Historic England

Arrangements for Handling Heritage Applications Direction 2015

92 NEW NORTH ROAD, EDGERTON, HUDDERSFIELD, HD1 5QP
Application No. 2018/65/92348/W

PROPOSED ALTERATIONS TO LOWER GROUND FLOOR

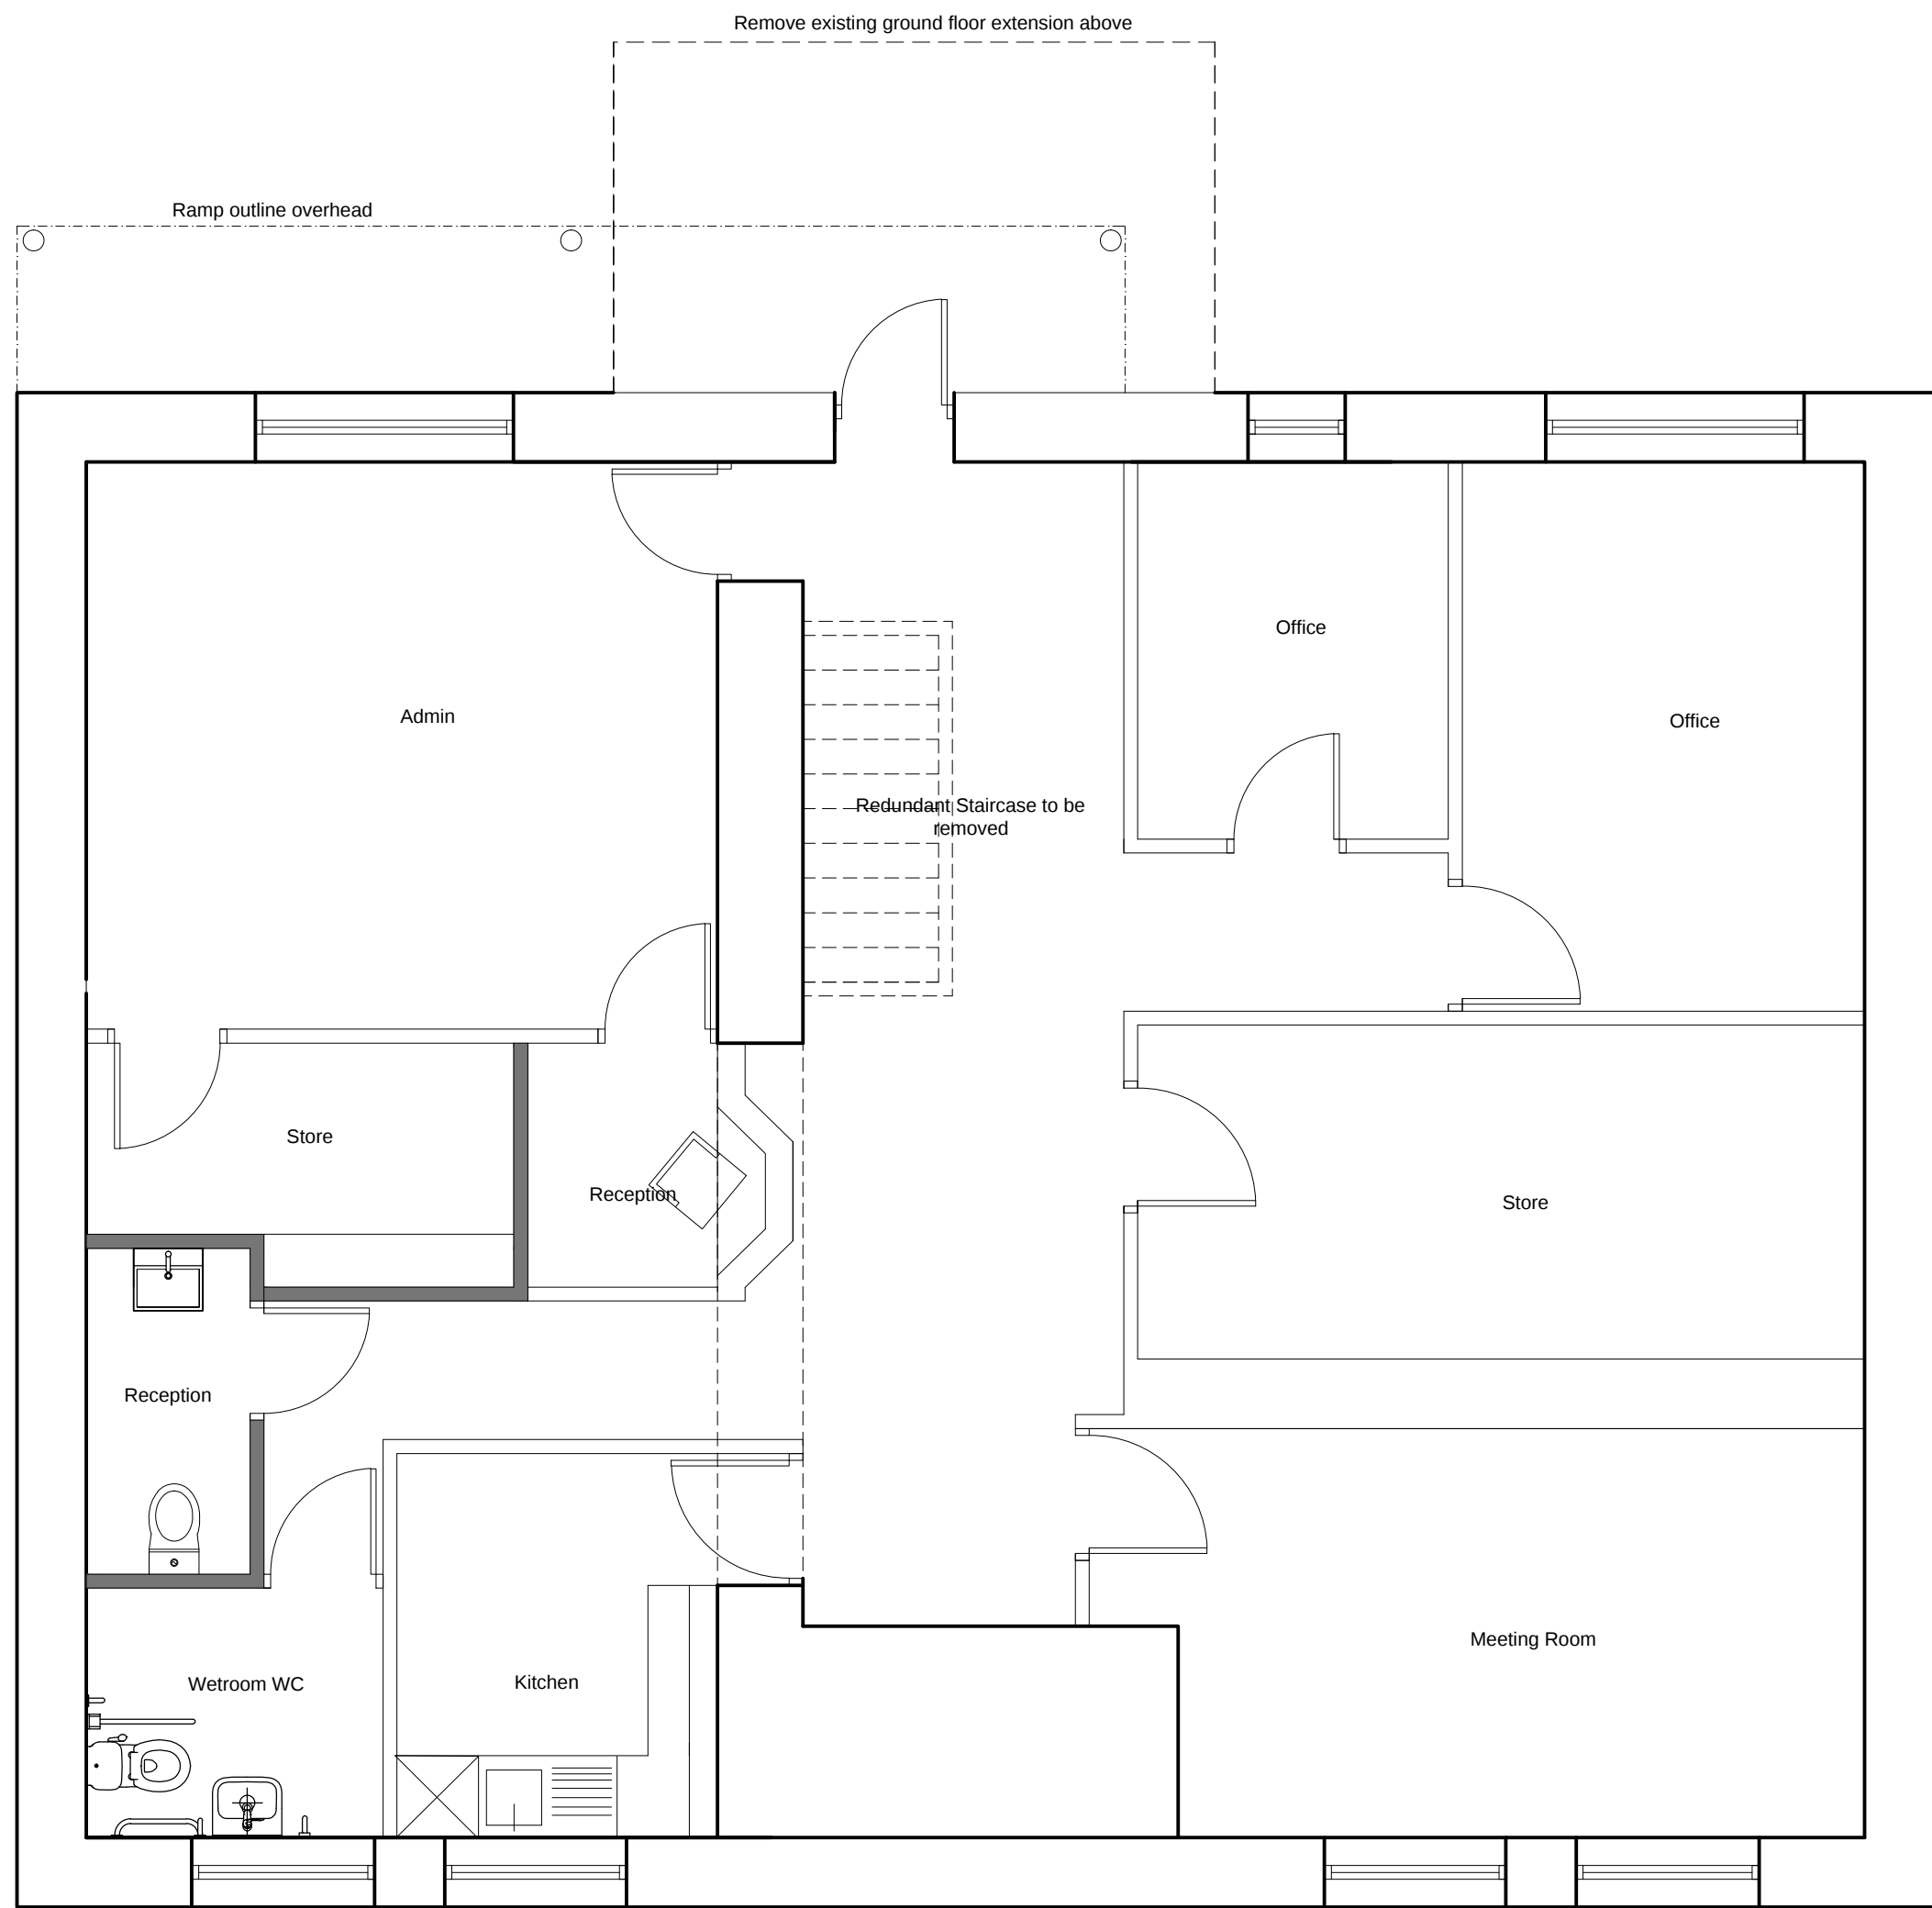
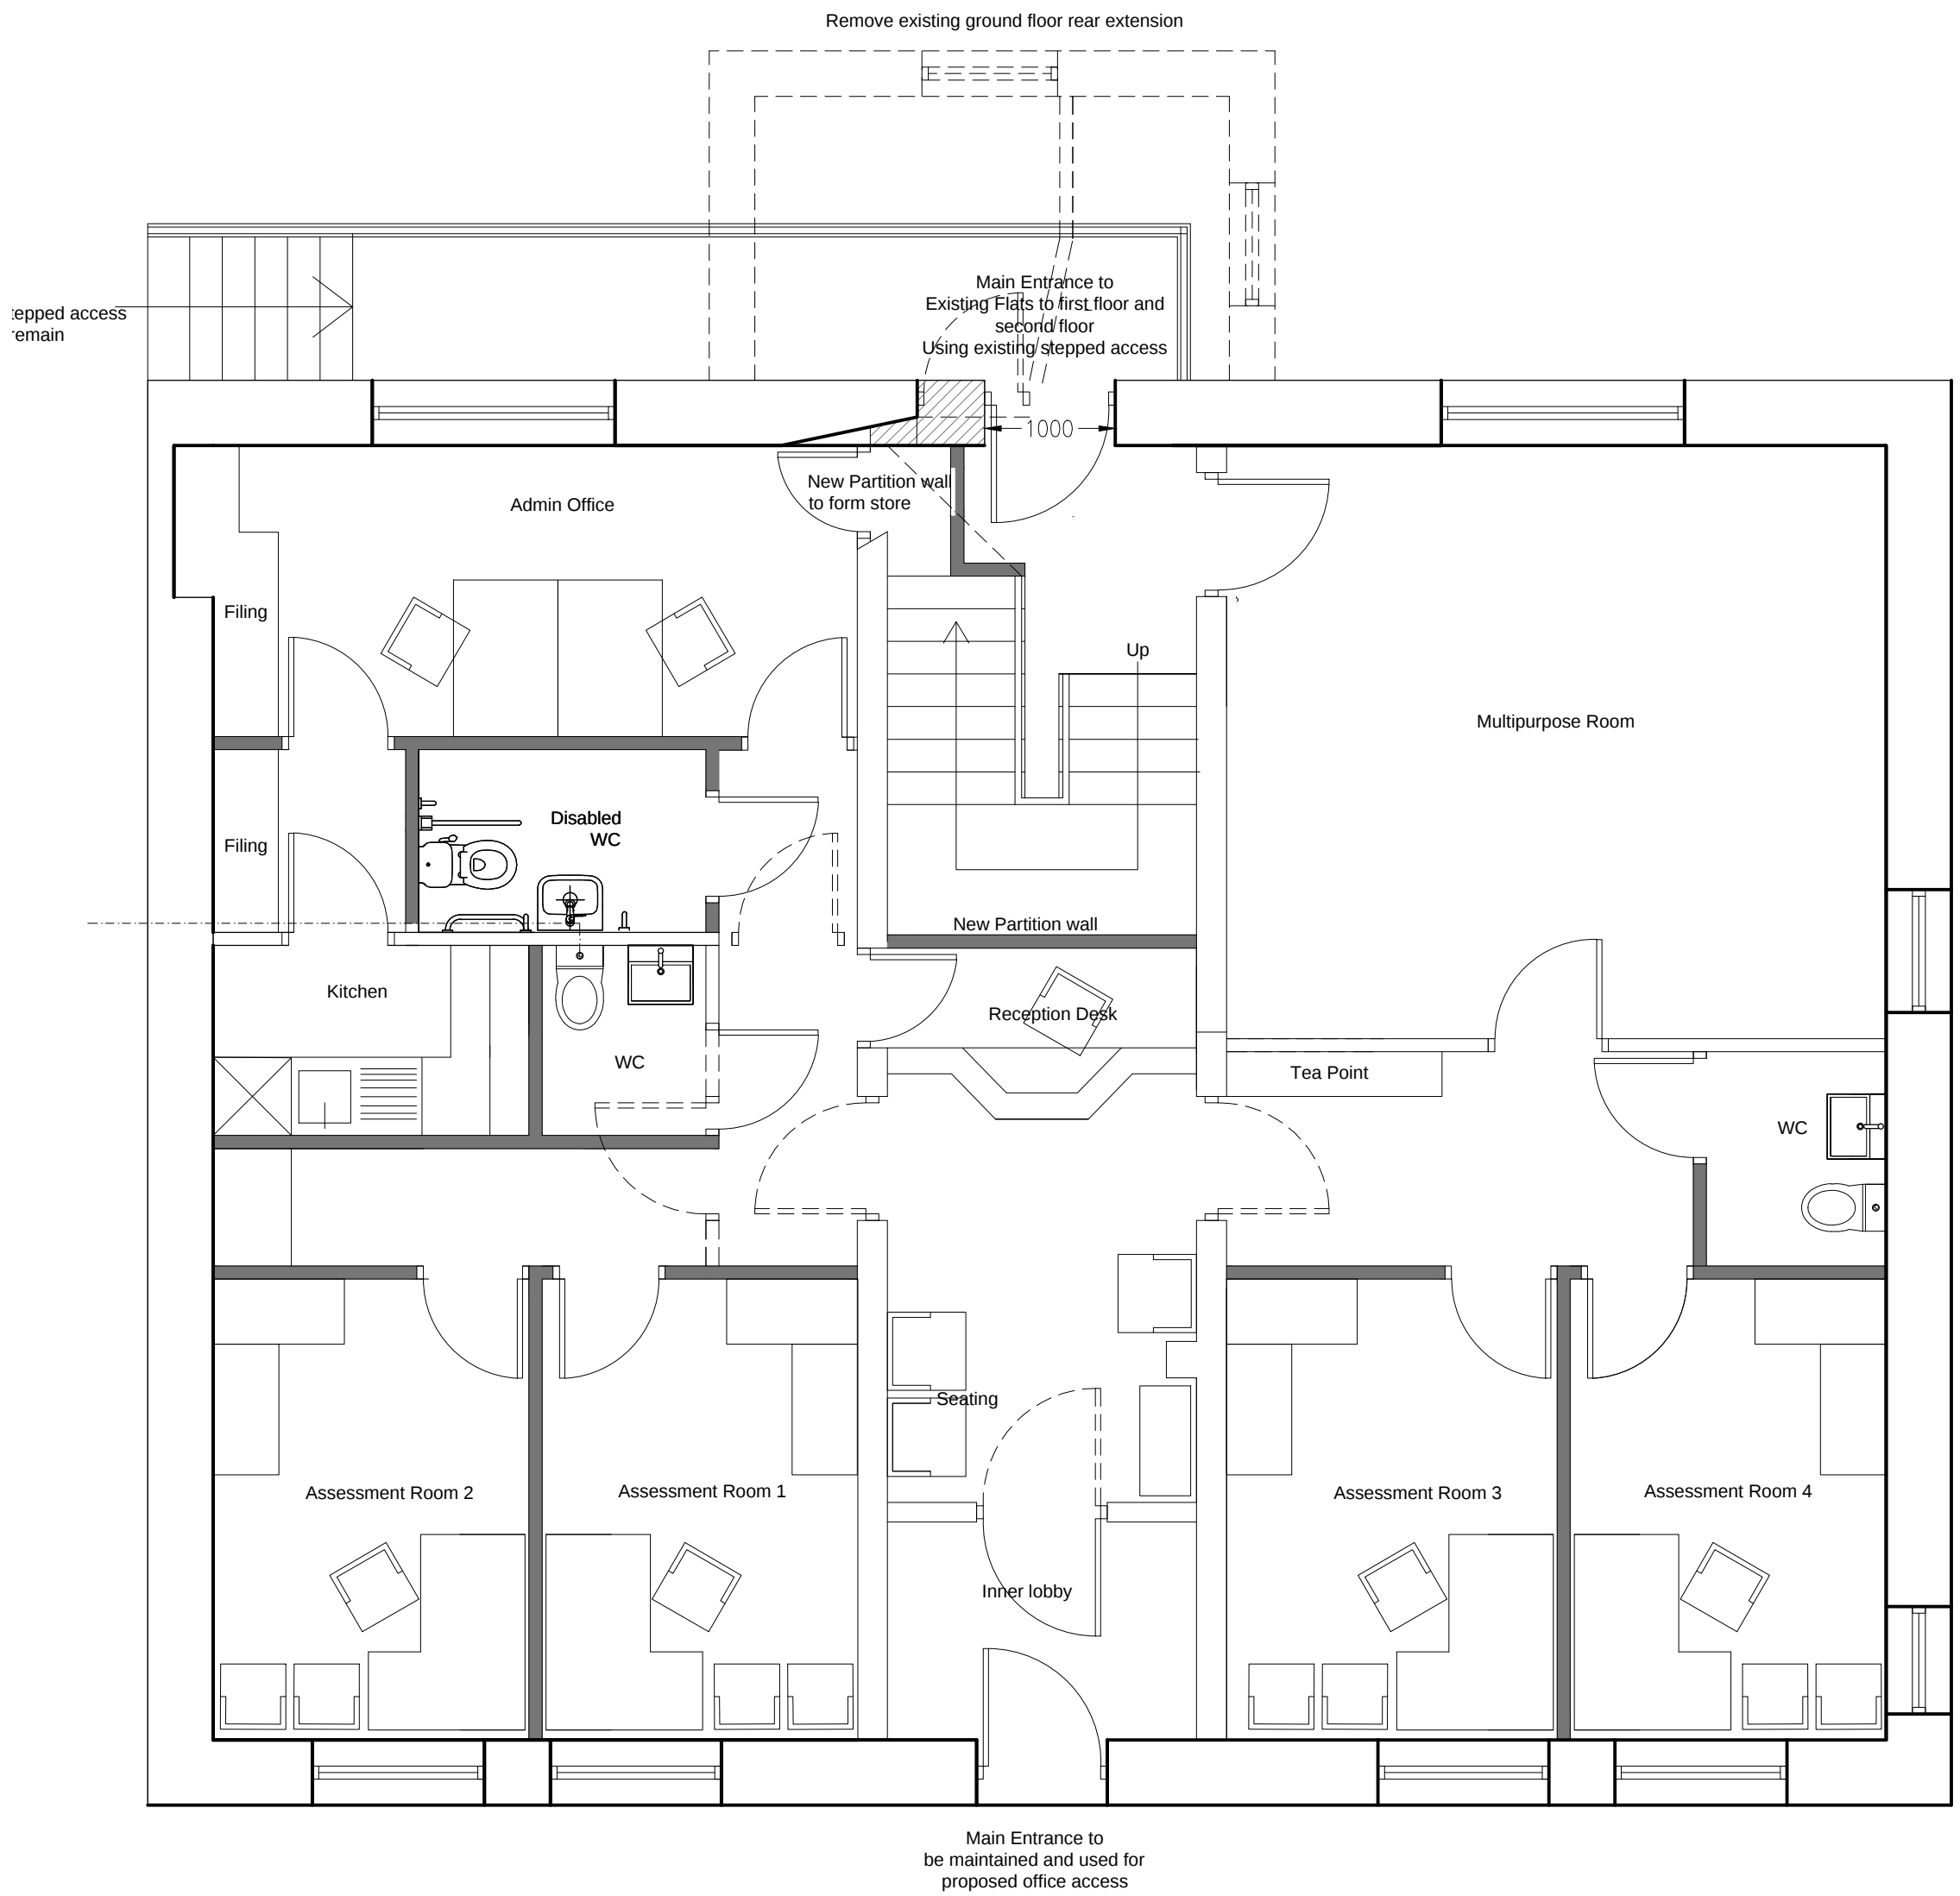
The current application proposes to remove the existing staircase between the lower ground and ground floors and to replace the staircase of the ground floor making significant changes to its plan-form. The application has not assessed the significance of these staircases; nevertheless, removal of historic staircases should be exceptional and requires very clear justification.

From the information provided with the application we have not been able to ascertain the age or design details of the two staircases, and as such it has not been possible to fully assess their contribution to the significance of the Grade II listed building.

There are two main issues to consider regarding the demolition of these staircases; physical loss of historic fabric and loss of evidence of the original plan-form of the building. Firstly, regarding the loss of historic fabric, we consider that further investigation is necessary to establish the age and extent of original material that survives within the staircases, as well as their current condition.

Regardless of the extent of the original fabric, the current layout of the staircases has the potential to help us understand how the building functioned in the past; it therefore has historical value through illustrating the historic plan-form of the building. The illustrative potential of the staircases should not be underestimated and any proposal for their removal/replacement would require very clear and convincing justification.

If your authority conclude that there is sufficient justification, that the public benefits of the scheme outweigh any harm to the listed building, and are minded to approve the application, a condition should be attached to any consent granted to secure a record of the staircase in its current location; including photographs and drawings, to be deposited in the local Historic Environment Record (HER). The relevant HER Officer may be able to provide further advice on the form that this recording should take.
